Memorandum

To: Marshall Hardy Jr.
From: Mike Nugent/Manager of Inspection Services
Date: 06/01/2004
Re: Cold Stone Creamery 180 Middle St. (032 I001)

I have commenced reviewing the plans for the above project and need the following information:

FIRST FLOOR EQUIPMENT PLAN

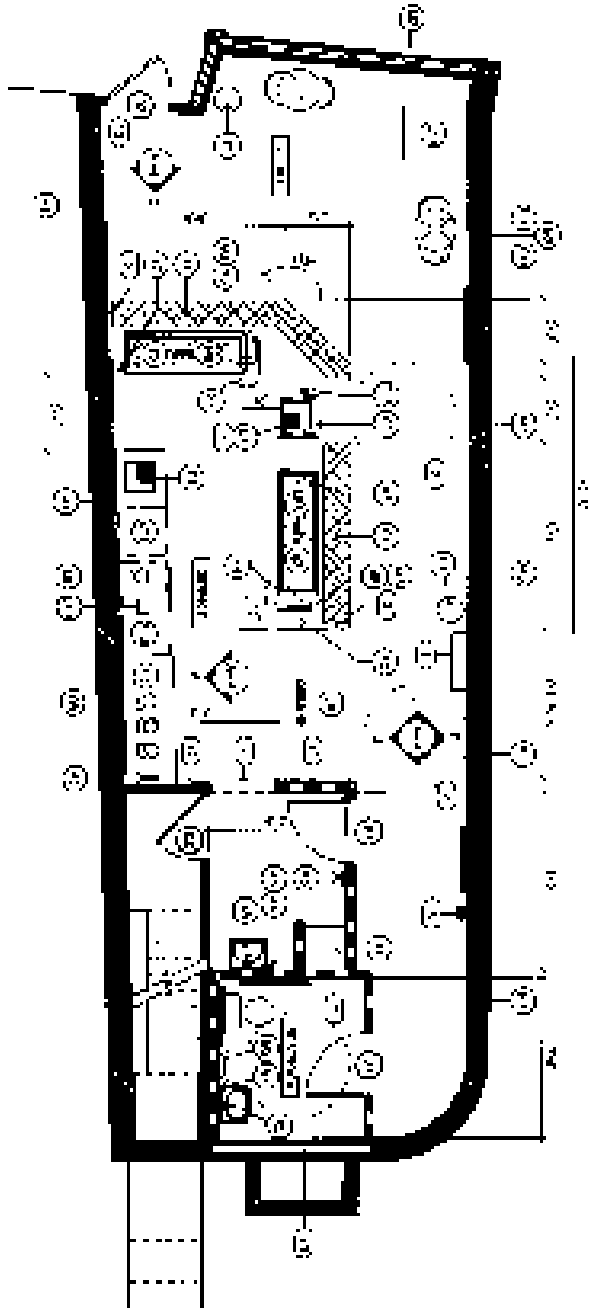
- 1) Attached are certification forms that need to be completed and returned, Thanks
- 2) Is there an actual seating plan?
- 3) Is the HVAC equipment creating additional loads on structural members and if so, how will they be addressed?
- 4) What will extent of their food prep/Cooking be?
- 5) Is there a grease trap contemplated?
